TM312-03F01 Ardex Warehouse Kemps Creek RfS Comments (r1)

## **Proposed Ardex Warehouse & Manufacturing Facility, 657-769 Mamre Road, Kemps Creek - Response to submissions - Noise and vibration**

Renzo Tonin & Associates (RT&A) has been engaged by The Trust Company (Australia) Limited on behalf of Altis Frasers JV Pty Ltd to undertake an operational and construction noise and vibration impact assessment (NVIA) to accompany the State Significant Development Application (SSDA) 25725029 for the proposed Ardex Warehouse and Manufacturing Facility at the proposed Lot 12, 657-769 Mamre Road, Kemps Creek (the Proposal).

E.2 Predicted operational noise levels – Sleep disturbance, L_{Amax}

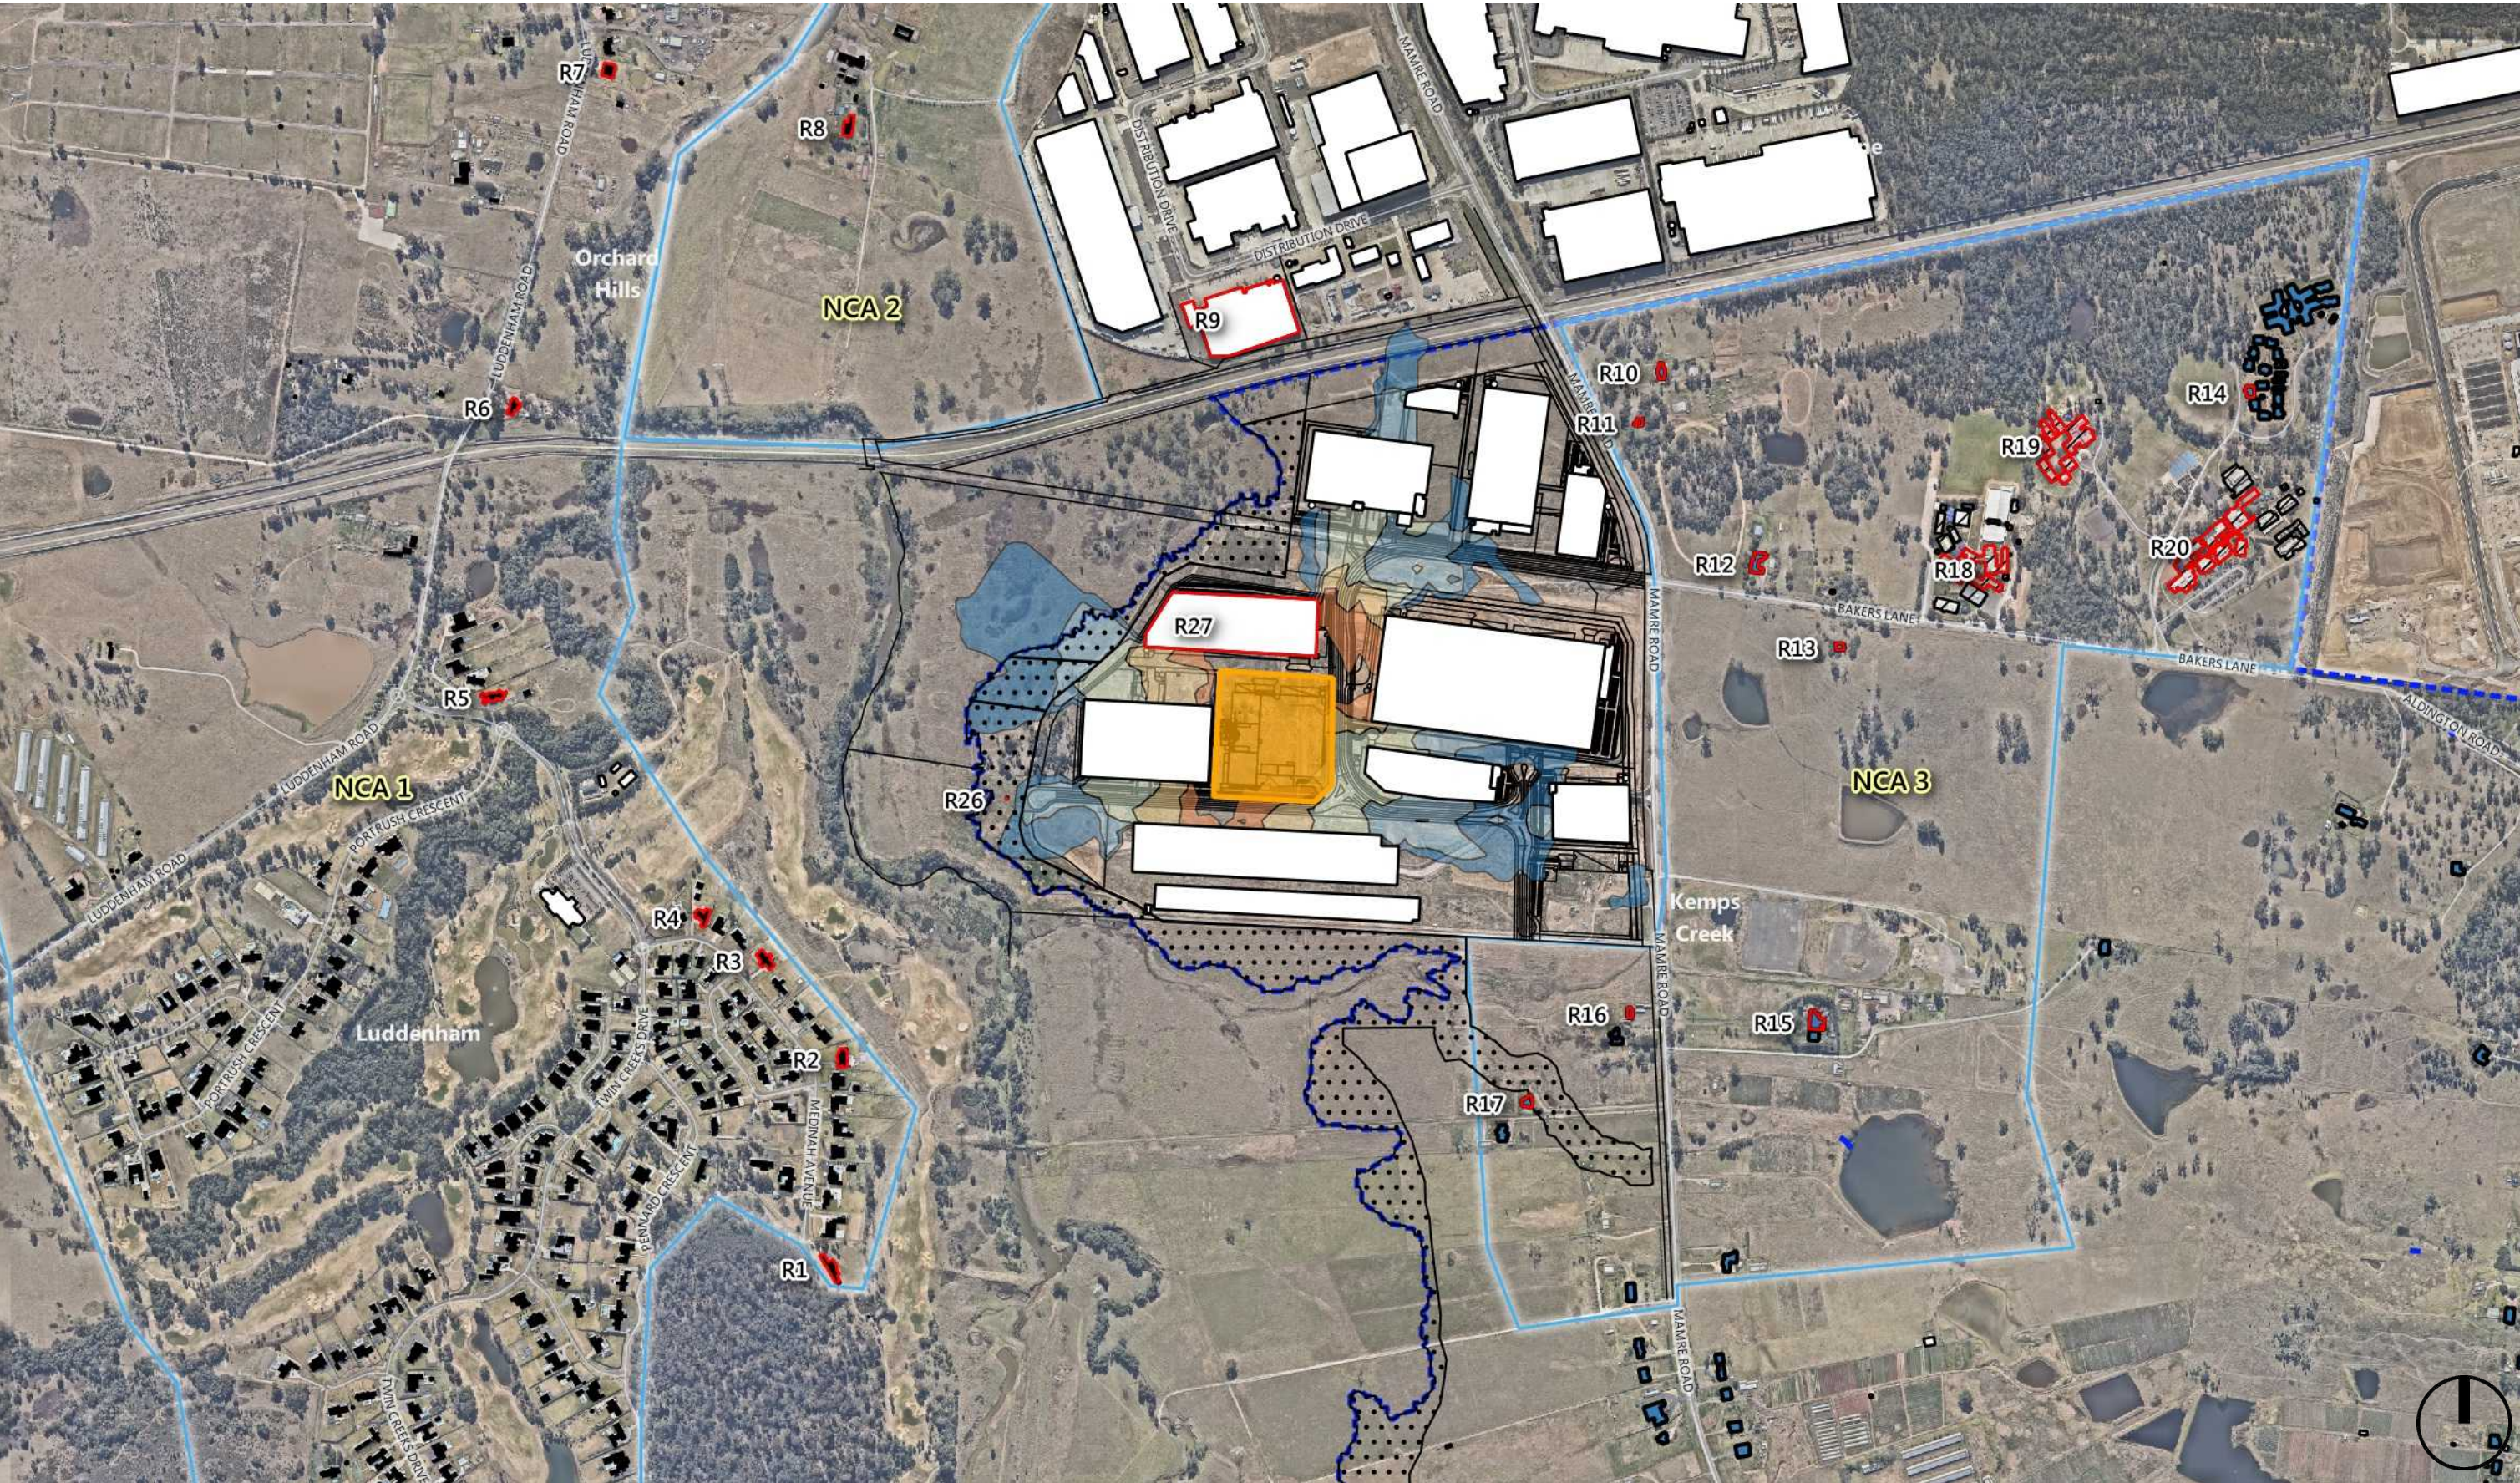
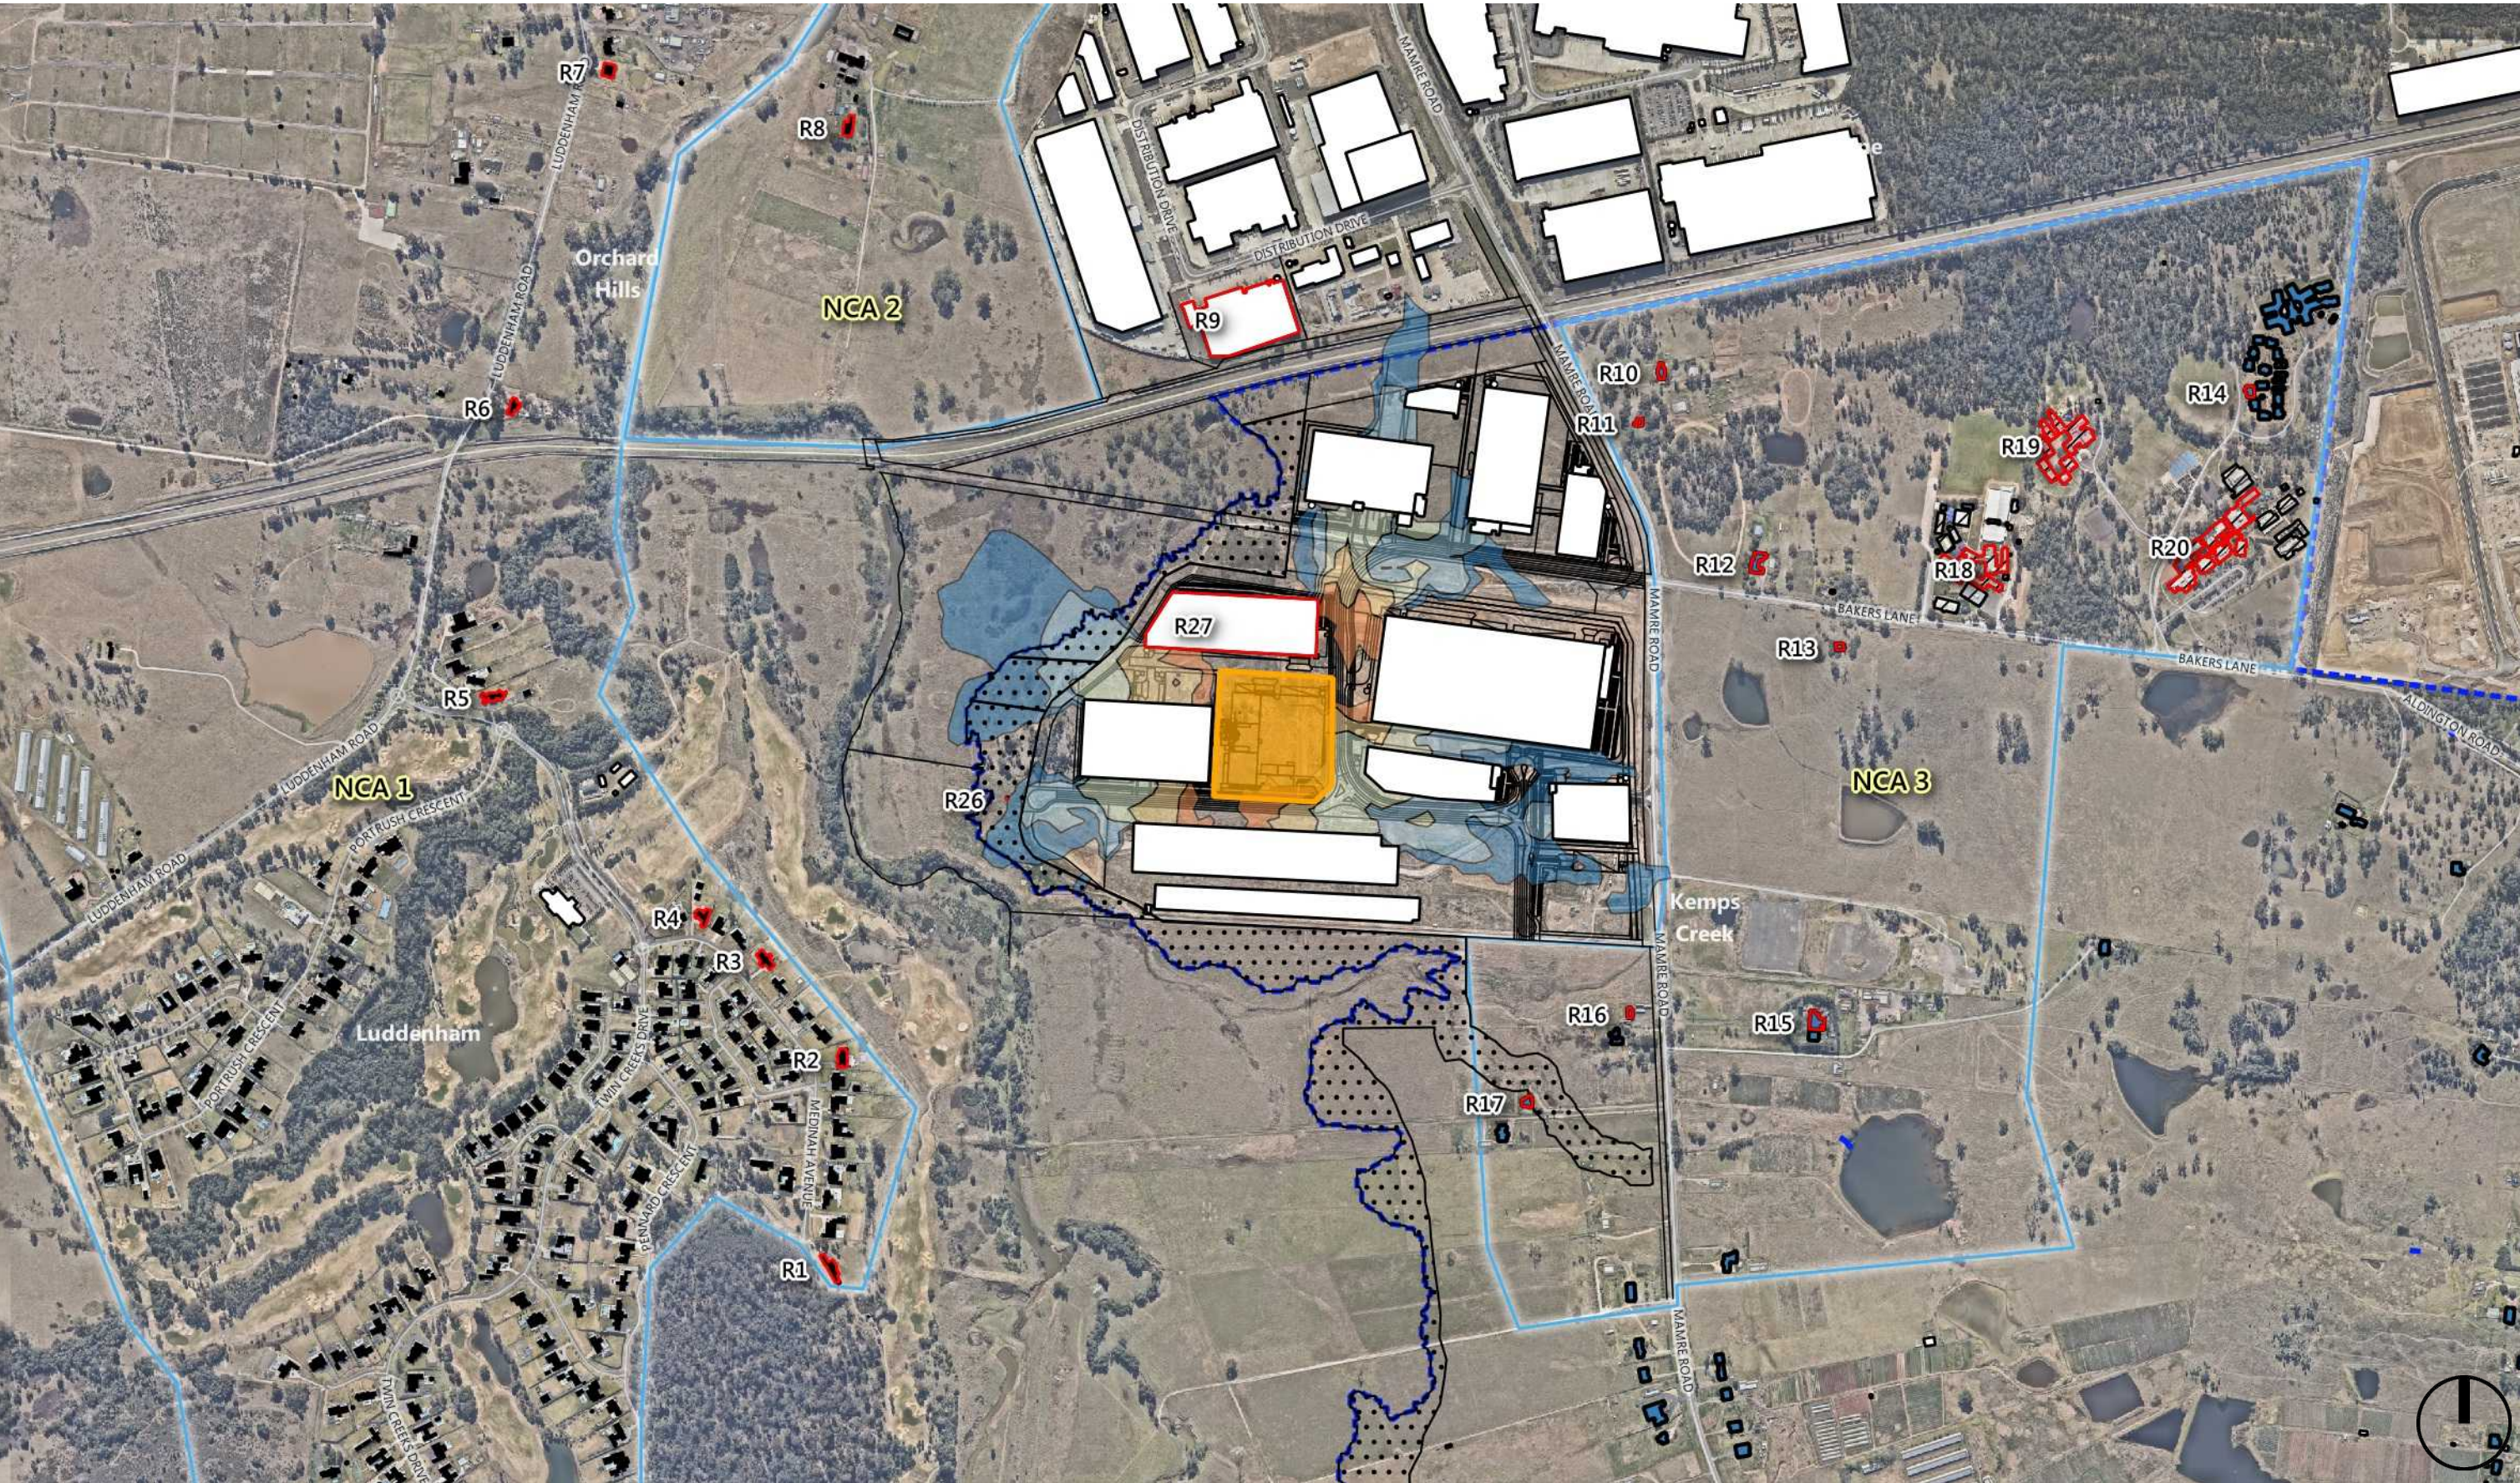
Item	Comments on NVIA	RT&A responses
18	The Department notes that Appendix B1 of the NVIA detailing the locality map, sensitive receiver type identification and operational assessment representative receiver locations is not provided. The Department also notes that Appendix E (Sections E.1 and E.2) detailing the predicted operational noise contours is not provided. The Applicant is required to update the NVIA to include Appendices B1 and E.	The updated SSDA NVIA includes these figures in: <b>Appendix B.1</b> - Locality map, sensitive receiver type identification and operational assessment representative receiver locations <b>Appendix E (Sections E.1 and E.2)</b> - Operational noise contours
19	The Department notes the NVIA considers impacts associated with the construction and operational phases of the development and the cumulative impacts. As discussed under the general comments above, the NVIA does not consider the proposed wastewater treatment plant in sufficient detail. The Department requires the Applicant to update the NVIA to include the proposed operational details of the wastewater treatment plan.	Wastewater treatment plant has been added into the updated modelling and predictions. Refer to response Item 2.
